WEST SUSSEX COUNTY COUNCIL CONSULTATION

TO:	Arun District Council FAO: Miss K Welch
FROM:	WSCC – Highways Authority
DATE:	16 May 2025
LOCATION:	Rigates Climping Street Climping BN17 5RQ
SUBJECT:	CM/12/25/PL Demolition existing buildings and erection of 1 No. self / custom build dwelling and garage with associated landscaping. This application may affect the setting of a listed building, is in CIL zone 5 and is CIL liable as a new dwelling.
DATE OF SITE VISIT:	n/a
RECOMMENDATION:	Advice

Drawing
Existing & Proposed
Site Plans

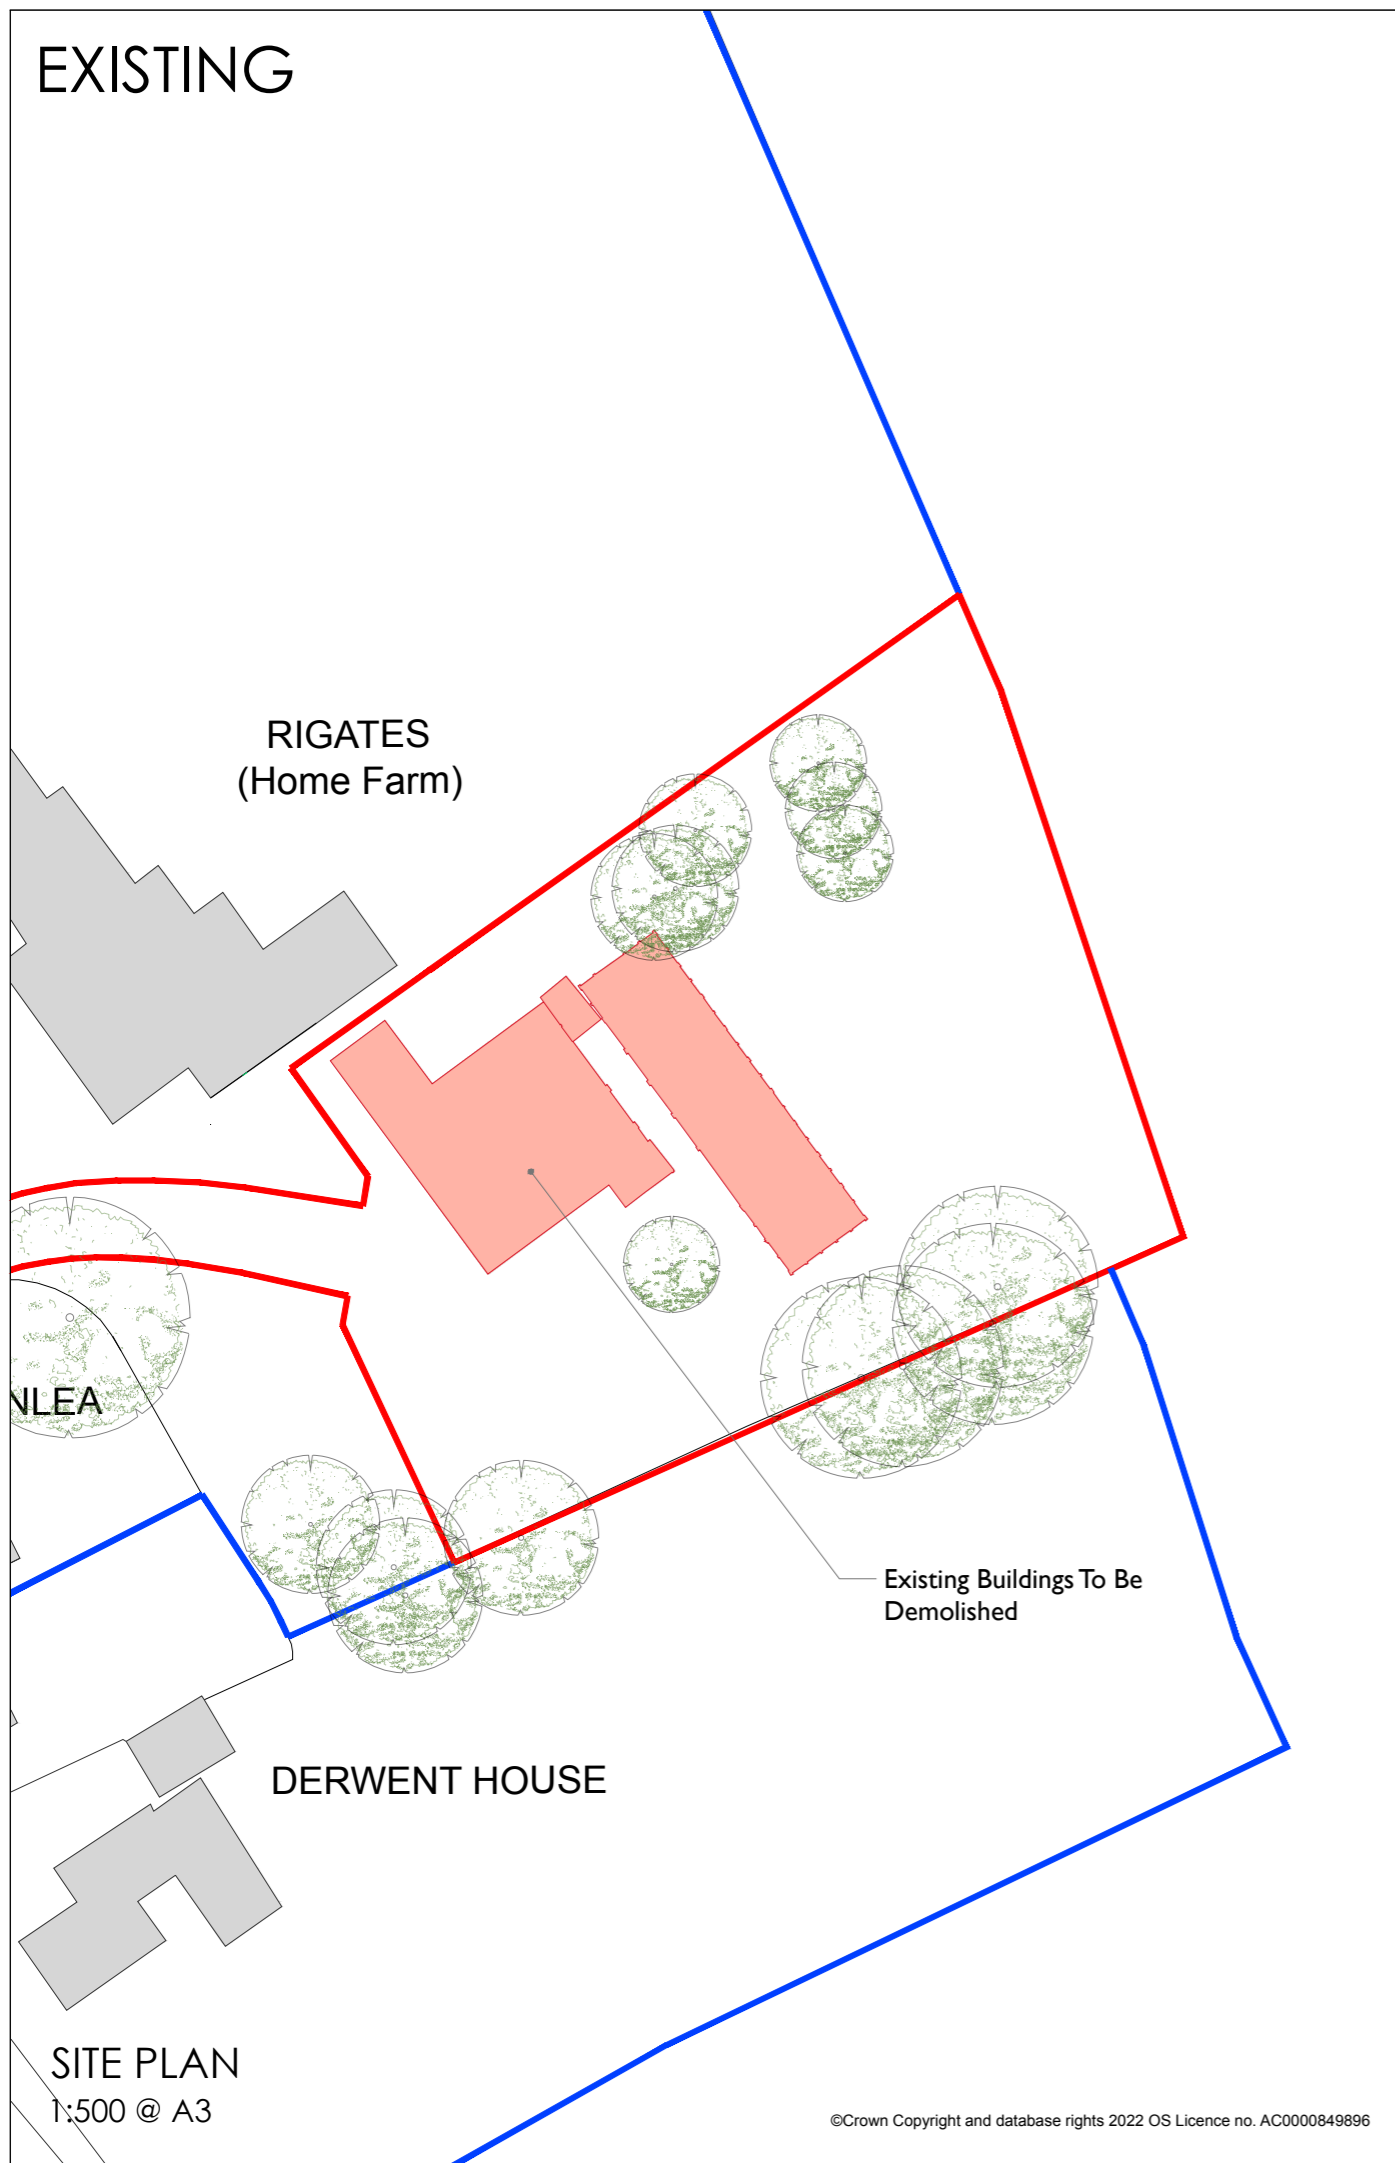
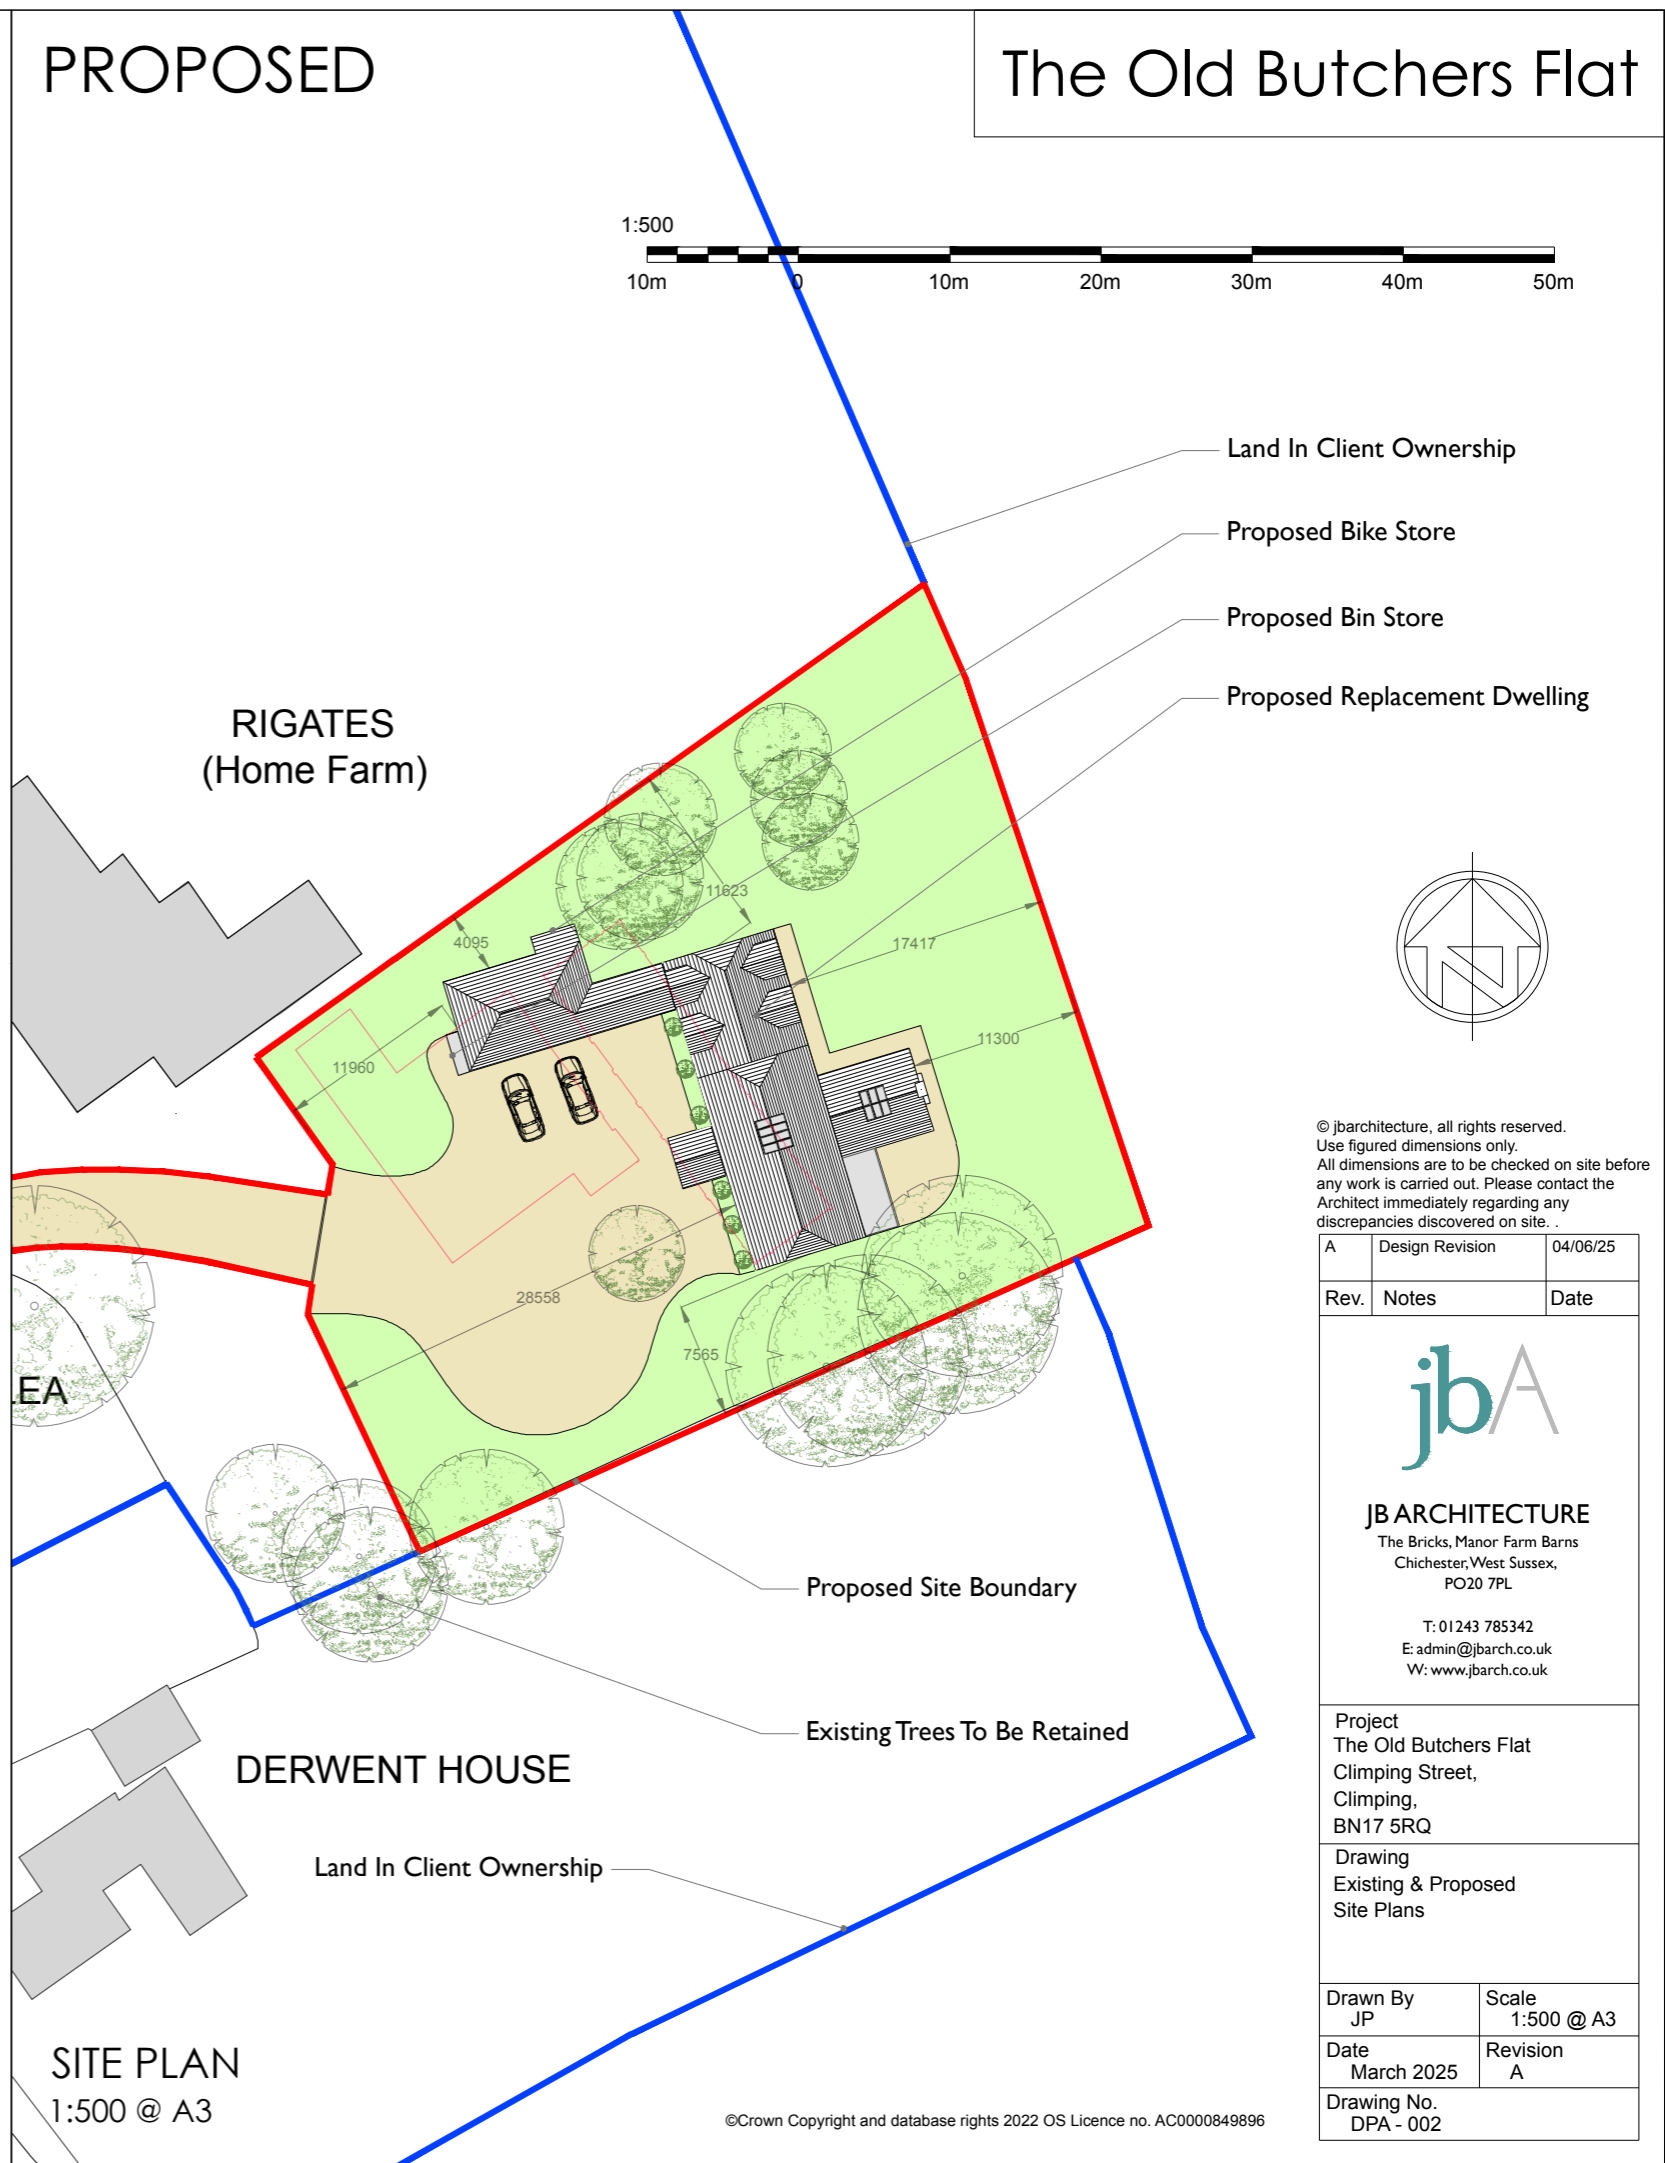
The three buildings subject of this application has served for some time as a three-bed flat, miscellaneous storage and office space. Three parking spaces have been allocated for this historic use and have been outlined as retained to serve the proposed dwelling. From observation of the submitted plans, there appears ample space for additional visitor and ad-hoc parking within the frontage. There is also sufficient space to perform a turn on site to egress onto Climping Street in a forward gear. Based upon the above information it is considered that there is already the principle of a residential property with vehicle access at this location and that vehicular movements would not be anticipated to materially differ over that which could currently be generated.

I have consulted the WSCC Parking Demand Calculator which identifies that the 3 parking spaces as proposed would be anticipated to satisfy the likely demand.

Should the LPA deem it a reasonable request, the applicant should provide a secure and covered cycle parking provision, to support sustainable alternatives to the use of a car.

No part of the development shall be first occupied until the car parking has been constructed in accordance with the approved site plan. These spaces shall thereafter be retained at all times for their designated purpose.

No part of the development shall be first occupied until covered and secure cycle parking spaces have been provided in accordance with plans and details to be submitted to and approved by the Local Planning Authority.
